A38 Derby Junctions
TR010022
8.15 Statement of Common Ground with
McDonald's

Statement of Common Ground
McDonald's

Version	Date	Status of Version
Draft	10 February 2020	Deadline 5 Submission

CUSTOMER TRACKS

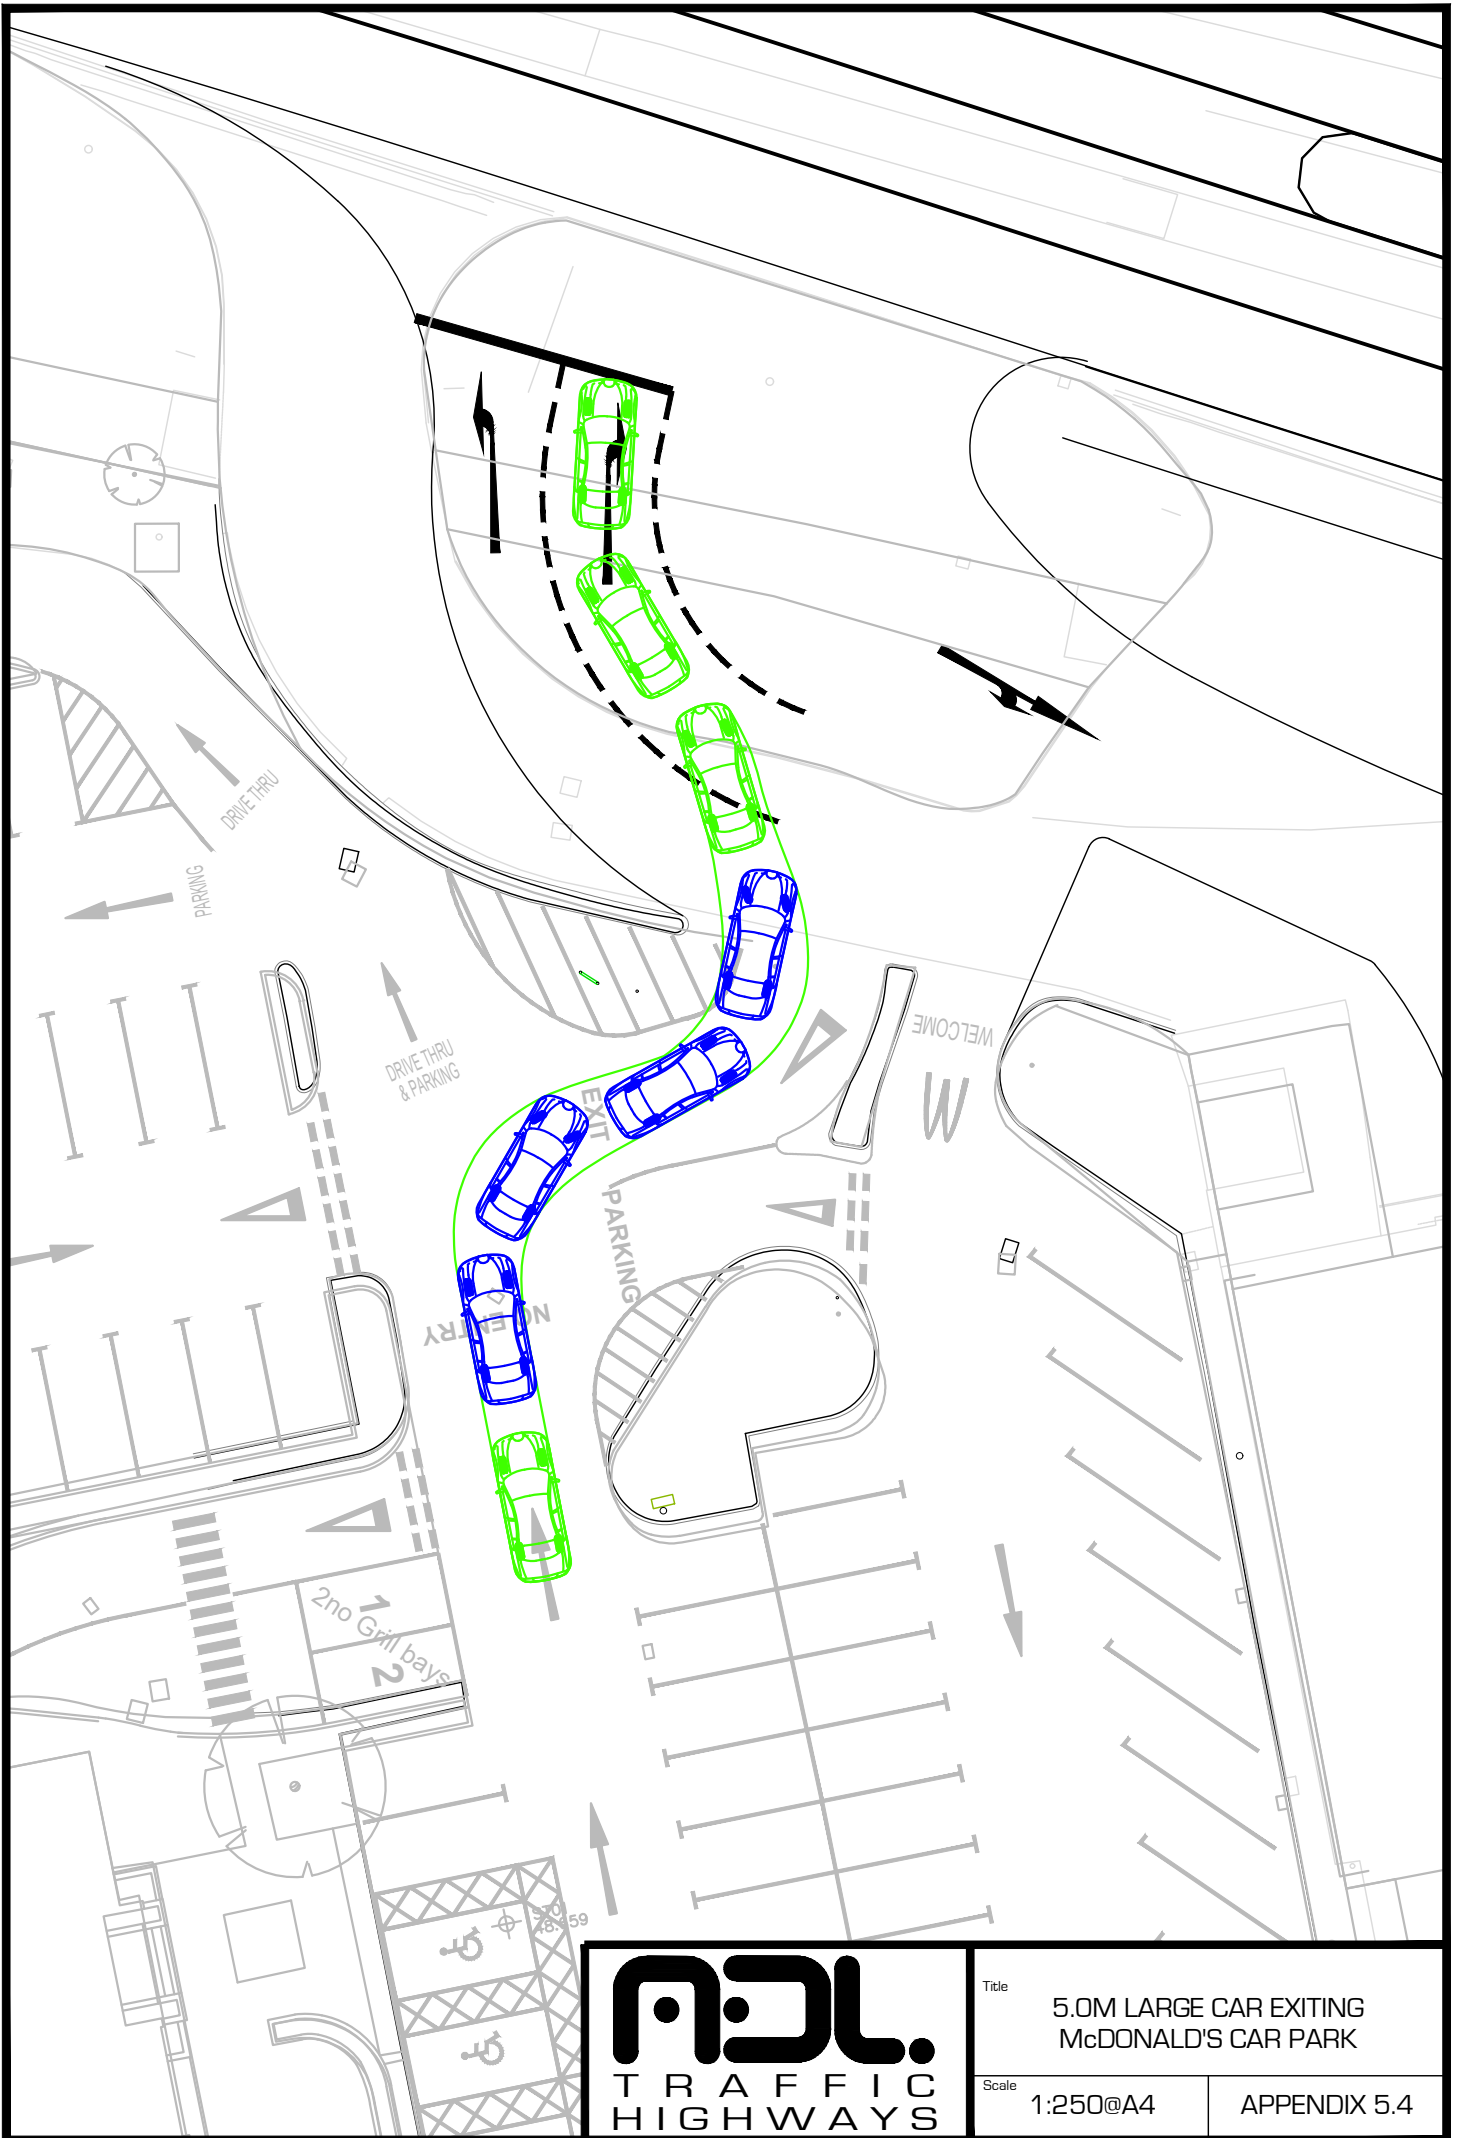
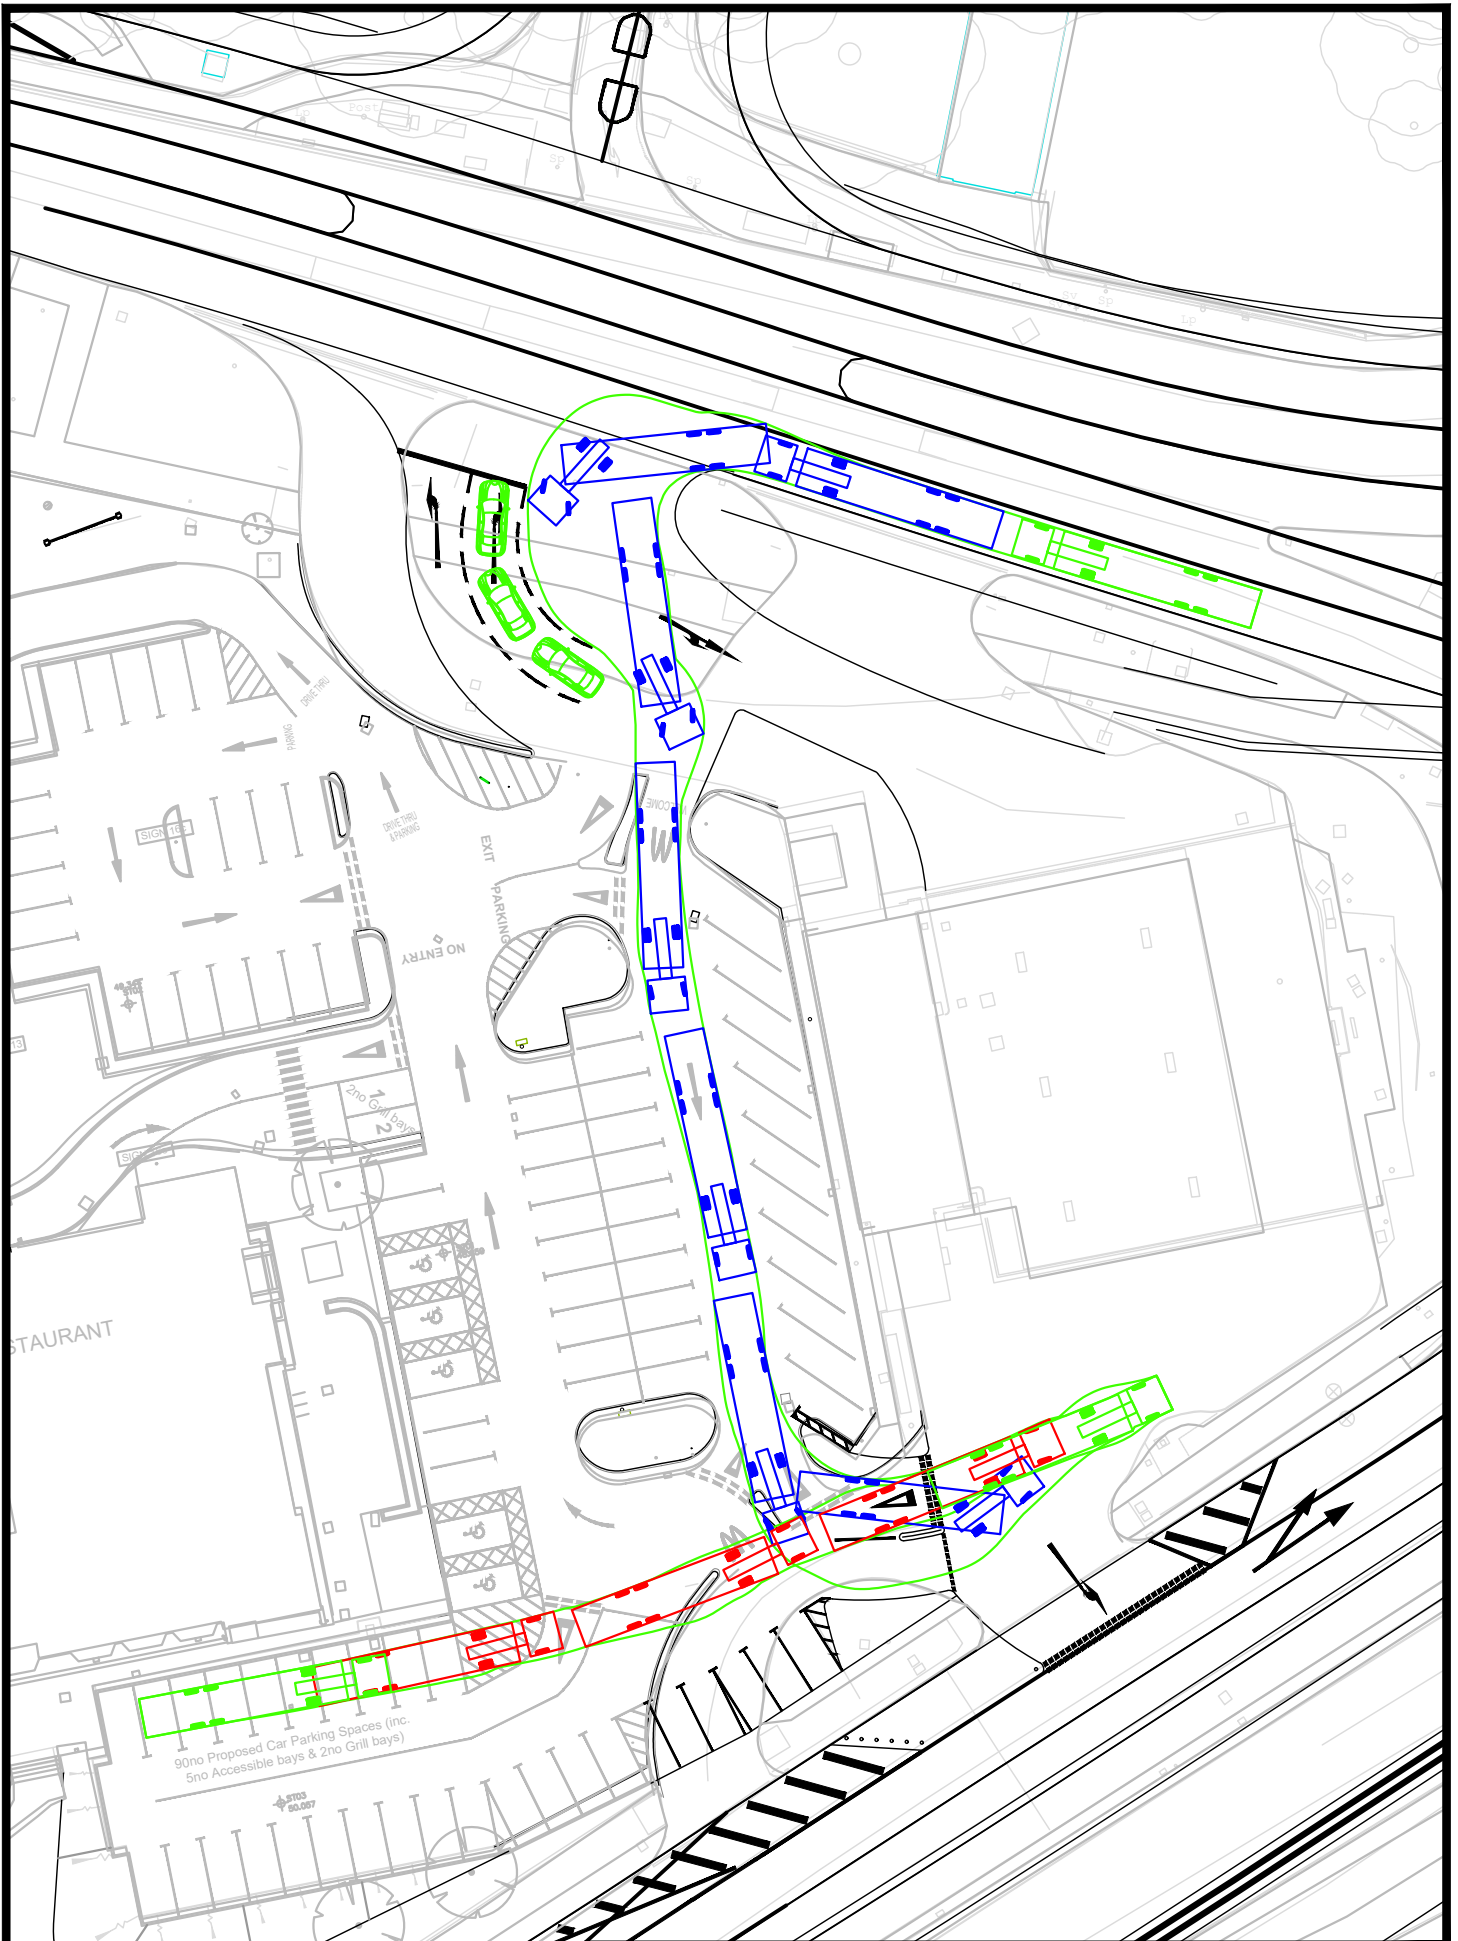
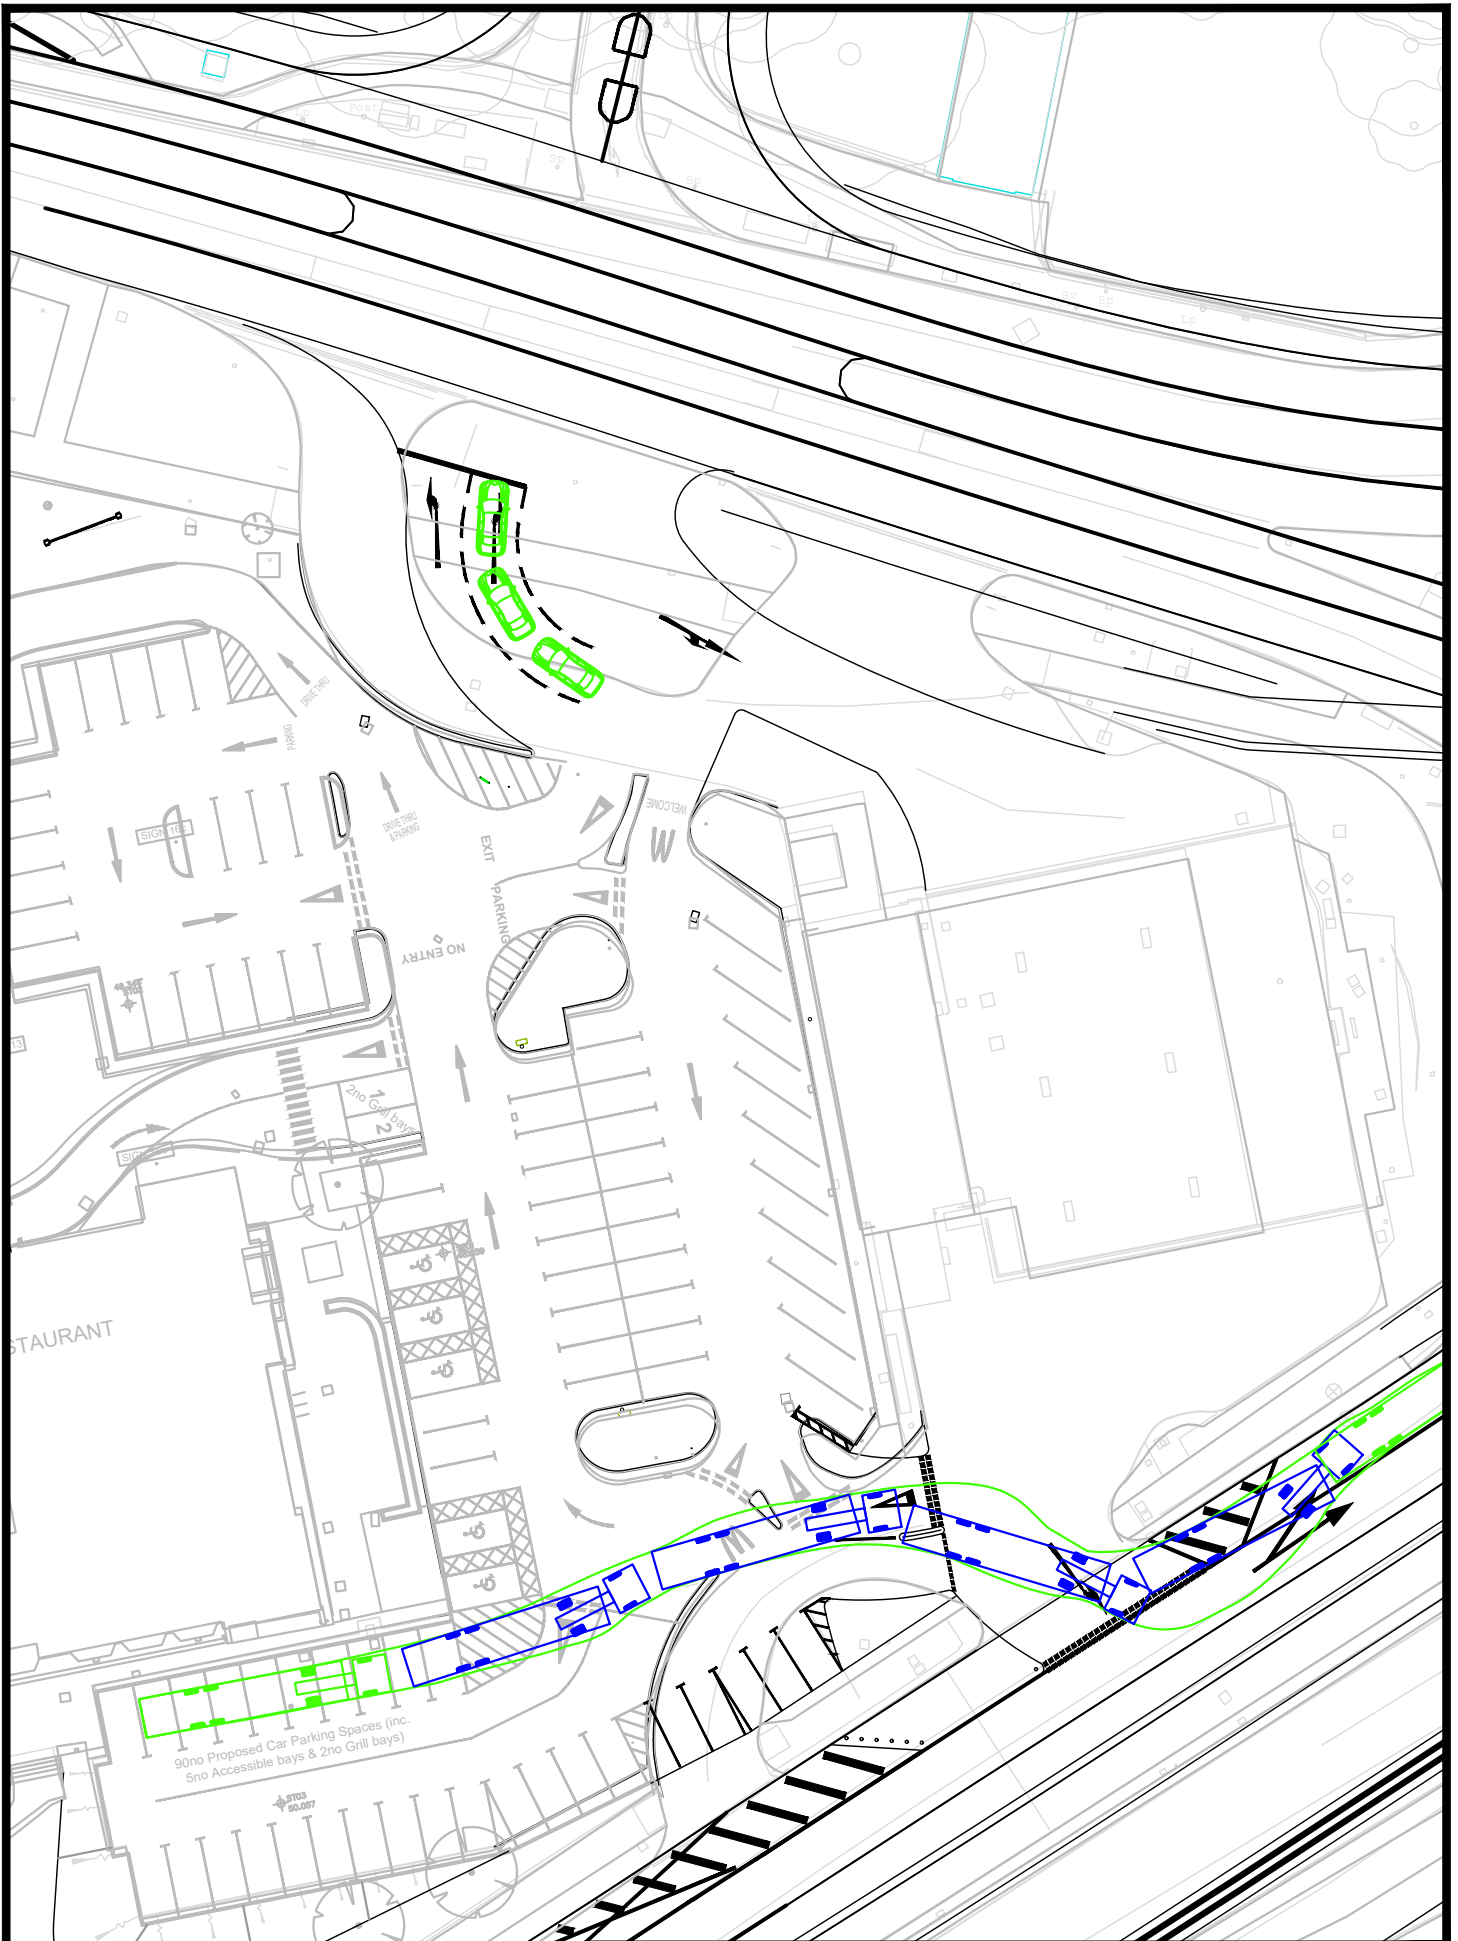
Issues Reference (see Appendix A)	Document	Paragraph Ref	Sub-section	Comment	Highways England Response	Status
Issue ref: I.1, access and potential impacts	Written Representation Comments*	Point 2	a)	<p>Currently, deliveries to the Property are received five times per week from the A38 entrance. The Works necessitate a change in delivery routes into the restaurant. The proposed route does not account for how McDonald's delivery vehicles manoeuvre around the Property or potential health and safety concerns. Delivery cages weigh hundreds of kilograms and McDonald's' car park is reinforced in the south part only. By closing the A38 entrance, delivery vehicles will no longer be able to service the Property; they are too heavy to safely cross the unreinforced north section of the Property.</p>	<p>Swept path diagrams have been provided to demonstrate that access for deliveries from the proposed new A52 access is feasible within the current car park layout (and crossing onto the Euro Garages land as they do at present).</p> <p>Highways England has advised that, during the detailed design stage, pavement surveys could be carried out to determine the strength of all parts of the car park – strengthening could be carried out as accommodation works if required.</p> <p>Highways England would welcome details of the existing car park construction (strengthened area and non-strengthened area) if available to be able to assess the load bearing capability.</p> <p>At the meeting of 15th Jan 2020, McDonald's noted that they have committed to taking core samples in their car park – the resulting information</p>	Under discussion
